SF2012/000358 | WST07/00087/10 and 11

**Narrabri Coal, Lot 152 DP816020 & others; Kurrajong Creek Rd, Baan Baa
SSD-10269: Stage 3 Extension, 11 Mtpa production and 540 FTE workforce, and
MP08_0144 MOD-7: Stage 2, bord and pillar mining of longwalls 201 and 202**

DWG No.		17380CAD001		
		FIGURE 1		
DATE STAMP		19 JULY 2021		
PROJECT No.	17380	SCALE	1:500 @A3	REV.
				A

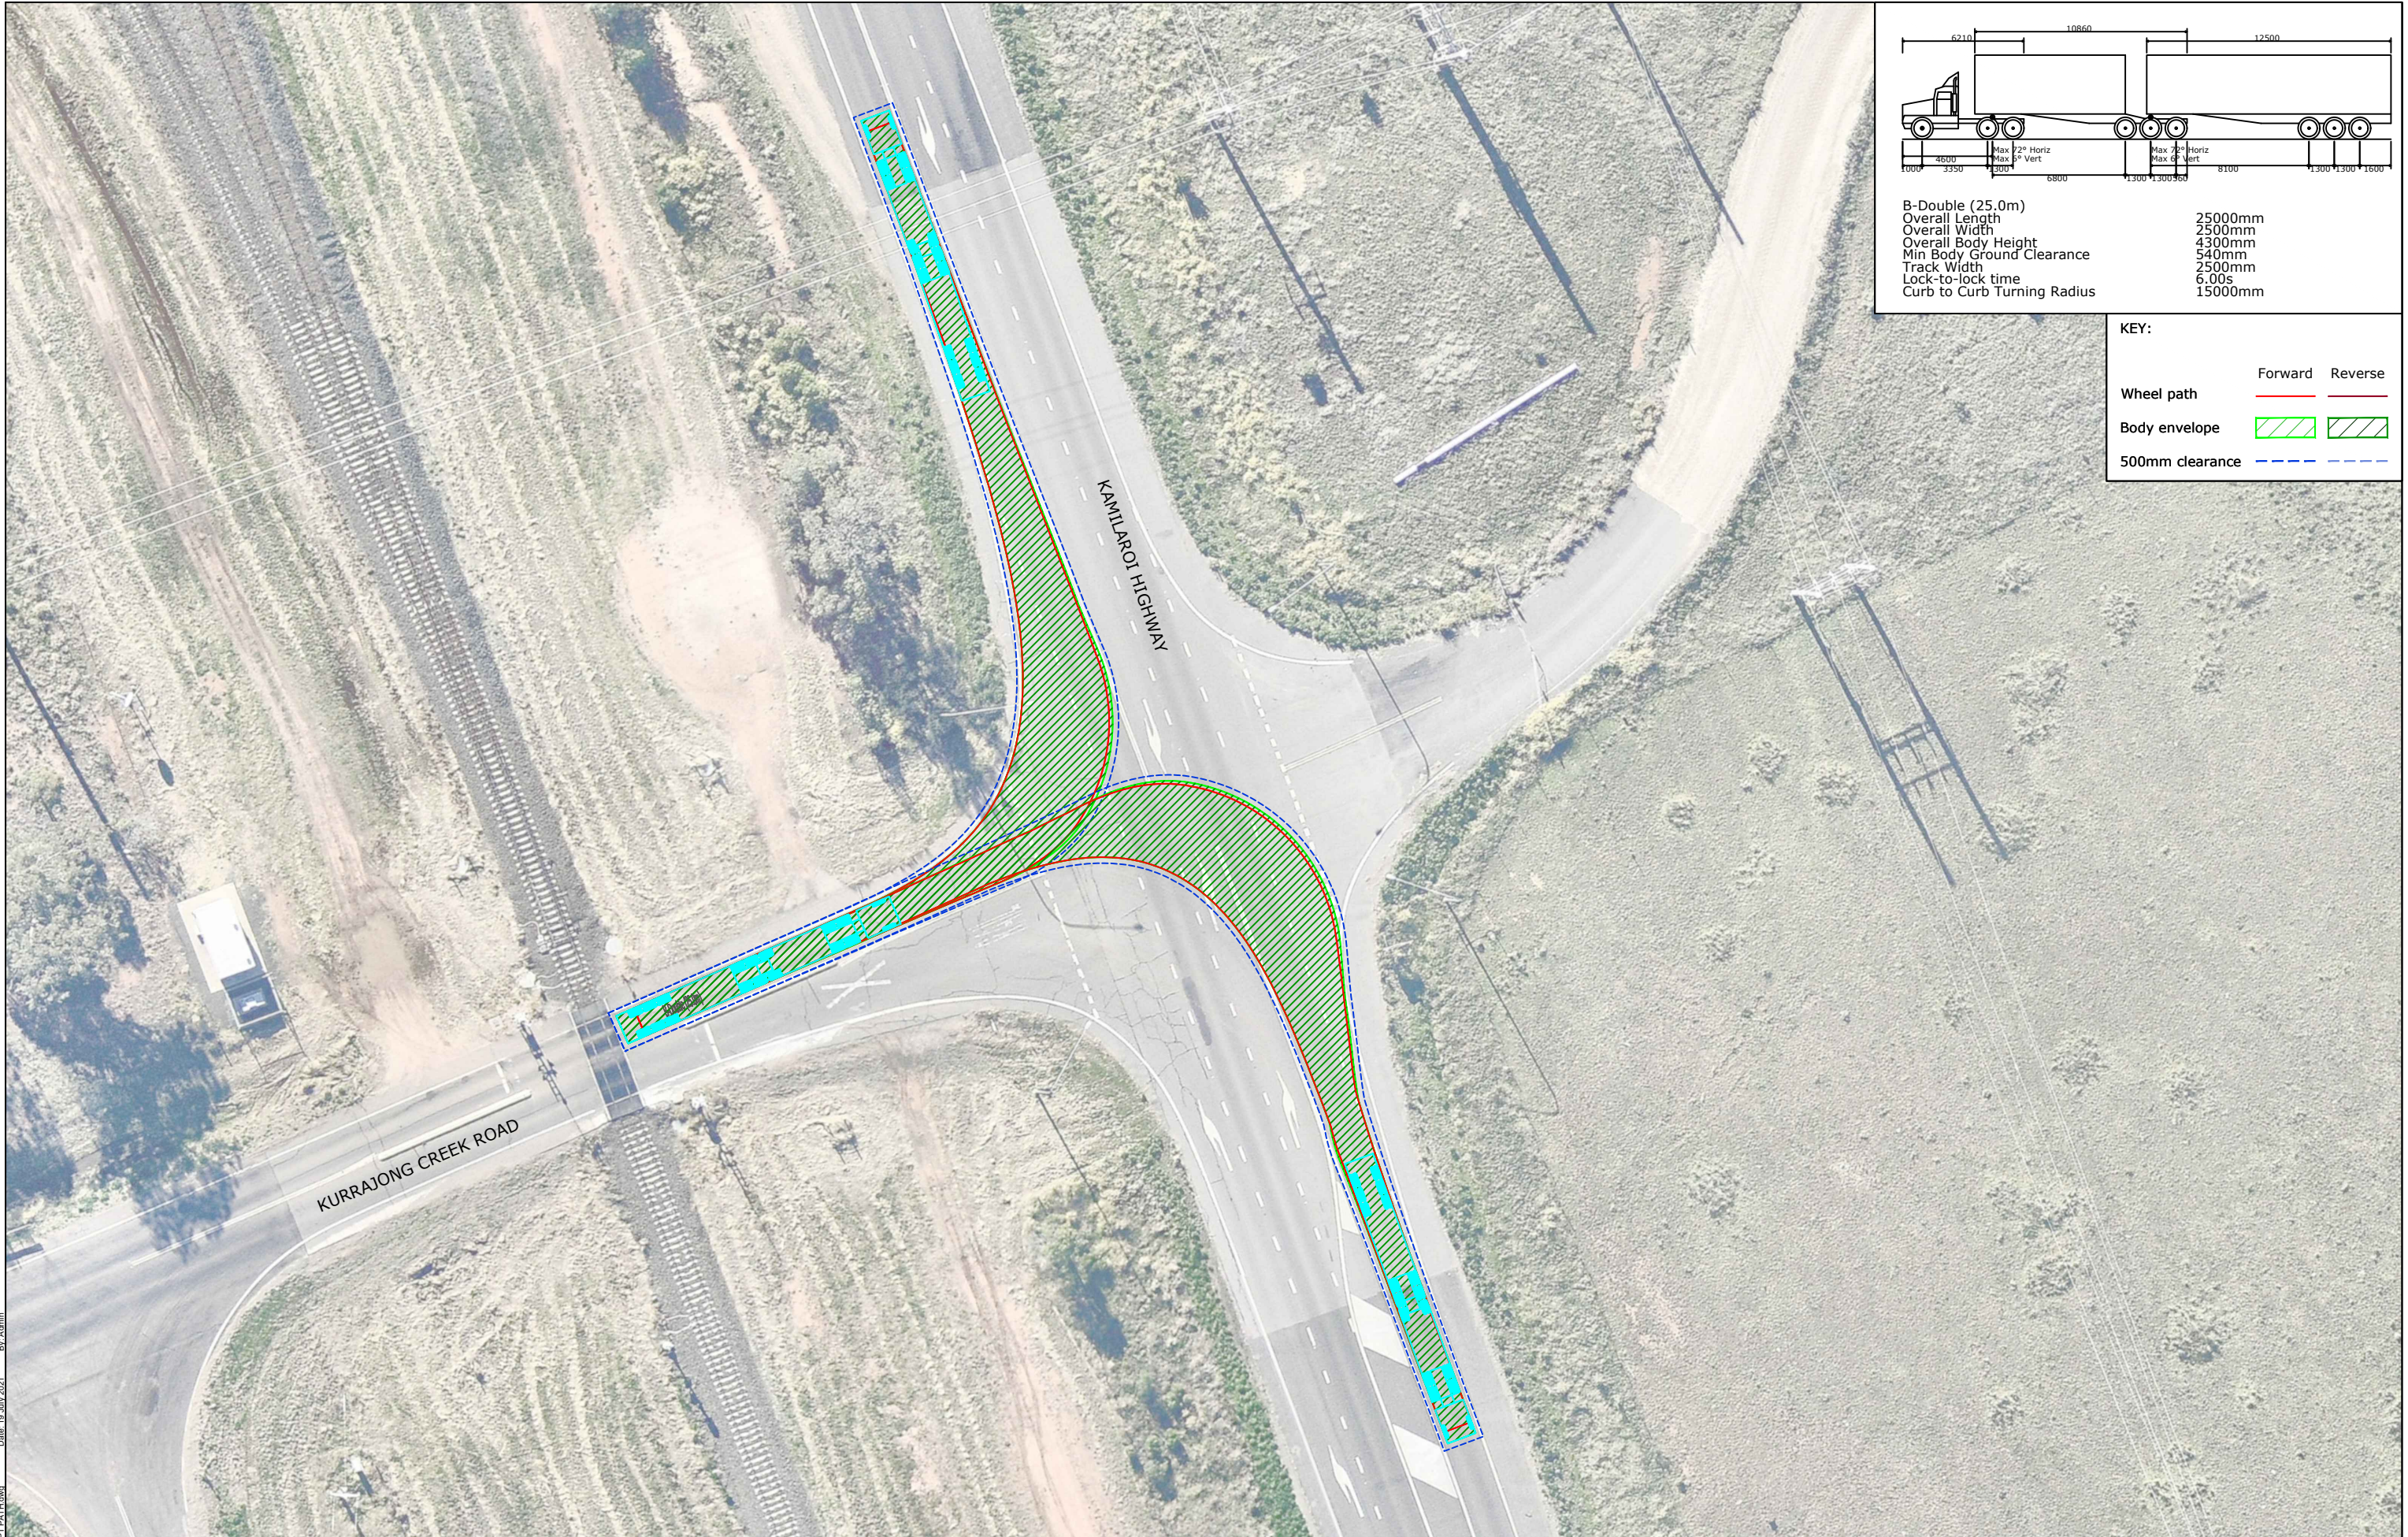
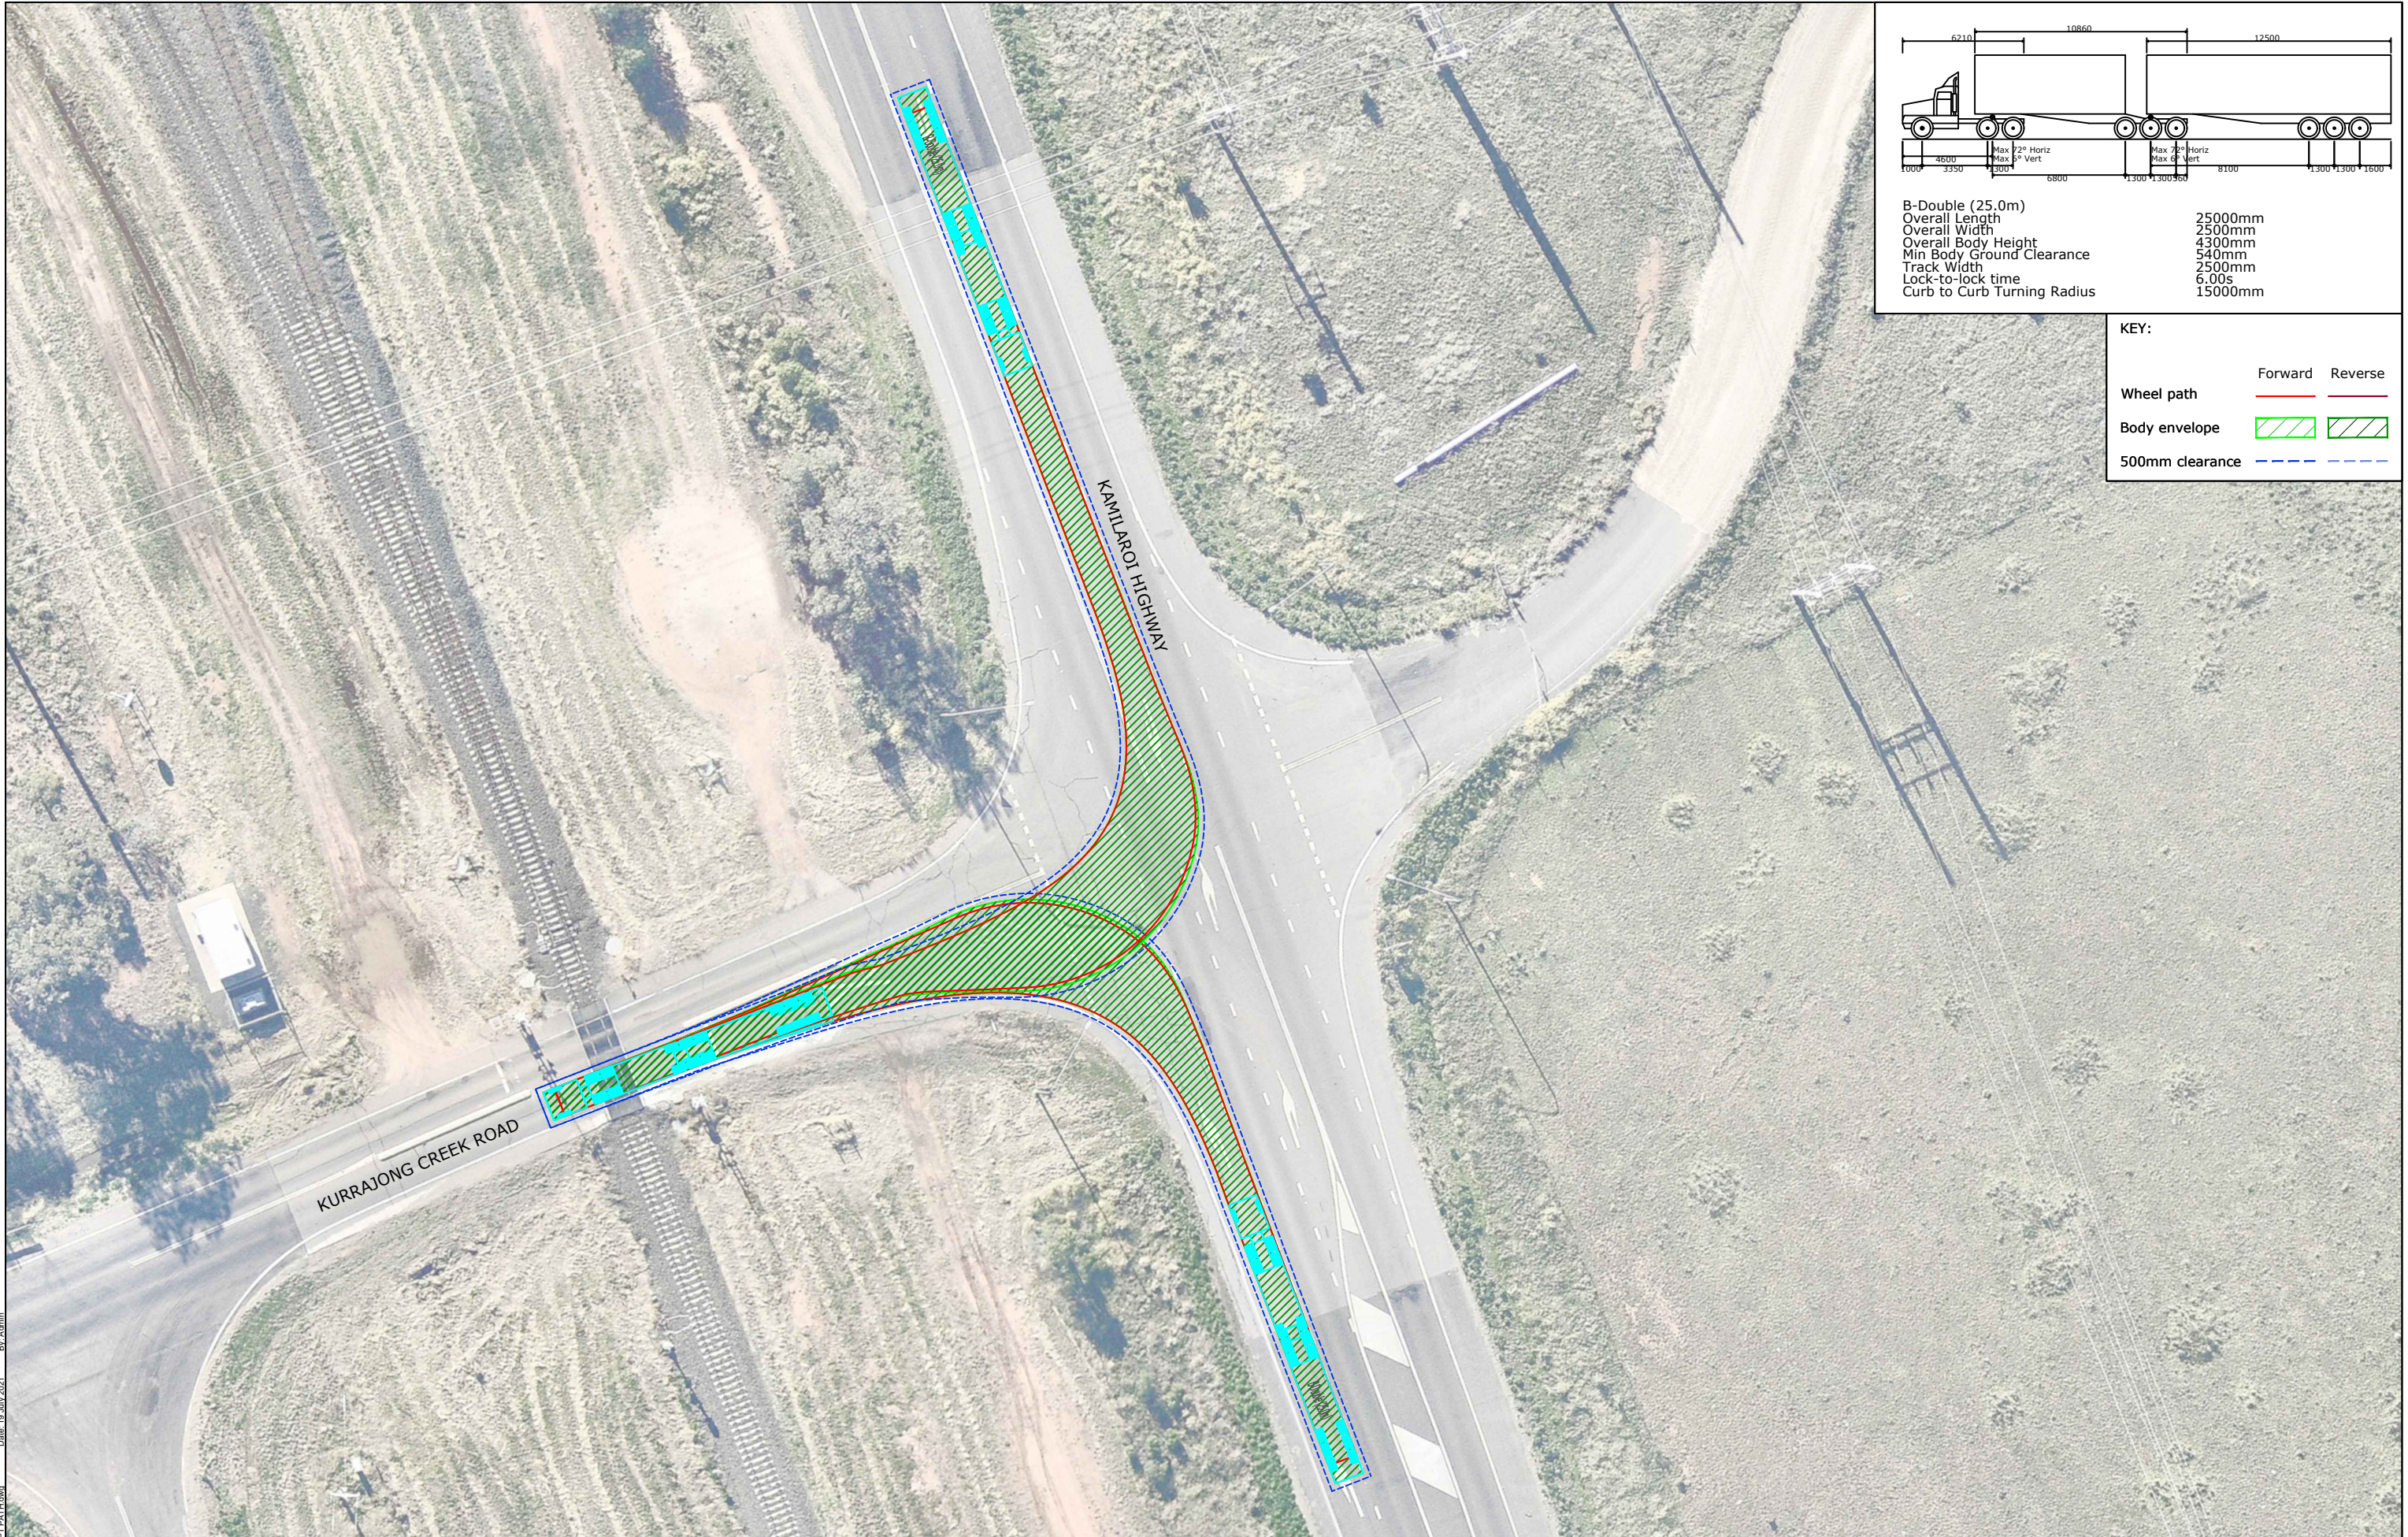
TfNSW concurs with the applicant's assessment (TTPP, Jul 2021) that basic warrants are met for a northbound Basic Left (BAL) turn treatment and a southbound Channelised Right Short (CHR/S) turn treatment, however, noting Austroads AGRD04A designs provides minimum deceleration lengths and no storage (except the provision for space for one design vehicle length for the turning vehicle).

It is also noted that the lanes exceed the length of warrant requirements apparently to provide vehicle storage in addition to the deceleration purpose of the lane due to the potential for extended queuing at the location based on the original project approvals which envisaged both shorter train delays and lower peak traffic volumes than the current circumstance.

It is critical that vehicles exiting the high-speed highway lanes have space to decelerate safely in accordance with the warrant required lane lengths. TfNSW is not satisfied that the existing development is resulting in safe outcomes at the intersection with respect due to the deceleration space of the lanes being exhausted by queuing vehicles. The proposed modification includes increasing staff numbers and will further exacerbate the danger created by queuing vehicles at the intersection.

The site and facilities layout, the operation of the development and/or the potential for modification of the mine access, including treatments at the intersection of Kurrajong Creek Road and Kamilaroi Highway need to be reconsidered and amended to adequately address these concerns.
